ACP Reference	322154-25
KCC Planning File	256003
Name	Briskalagh Ltd.
Address	In the townlands of Acragar, Ballyconra, Ballycuddihy, Ballyroe, Ballyroe (Grace), Ballyroe (Maher), Baunaniska, Boherkyle, Briskalagh, Brittas, Clone, Coolnapisha, Curraghduff, Freshford, Freshford Lots, Graigueswood, Grange, Huntstown, Kilmanagh, Knockeenglass, Knockown, Moatpark, Monabrika, Monavadaroe, Moneenaun, Oldtown, Oldtownhill, Parksgrove, Picketstown, Rathealy, Sart, Sweethill, Tobernapeastia, Tullaroan, Upperwood Demesne, Co. Kilkenny.

Subject: An Coimisiún Pleanála Reference 322154-25

KCC Planning Application Ref. 2560003

I make this observation as a party to the First Party Grounds of Appeal (GOA) submitted by Briskalagh Ltd, in response to the Further Information provided in respect of the proposed wind farm development within the Kilmanagh, Ballycallan, and Tullaroan communities.

Figure 1 Cumulative Predicted Noise Contours

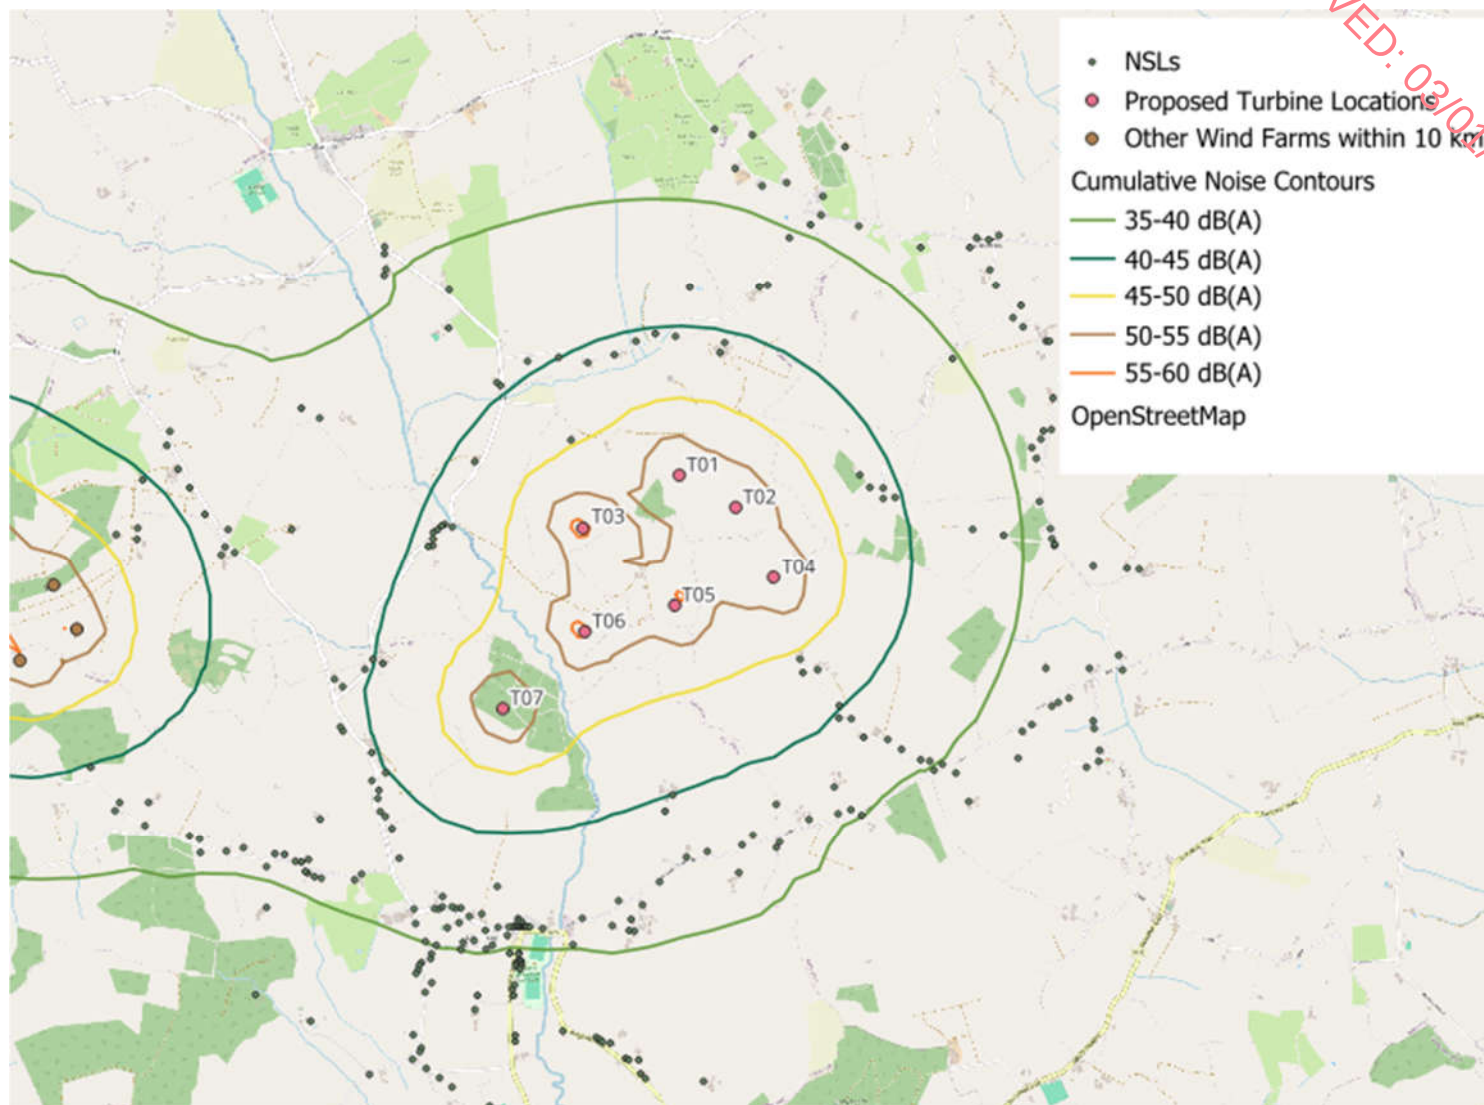
Pages 116-117 present numbers of existing/permited wind farms and associated turbine. A total of **6** no. existing/permited wind farms have been identified within the cumulative study area.

The exact numbers of *existing/permited* turbines are given and MKO comes to a total of **23** turbines. However, this is **incorrect**. This should be **29 turbines!**

Including the proposed 7 turbines for Briskalagh, the total turbines surrounding Kilmanagh/my home would be 29 plus 7 is 36 turbines, divided into 7 separate wind farm companies.
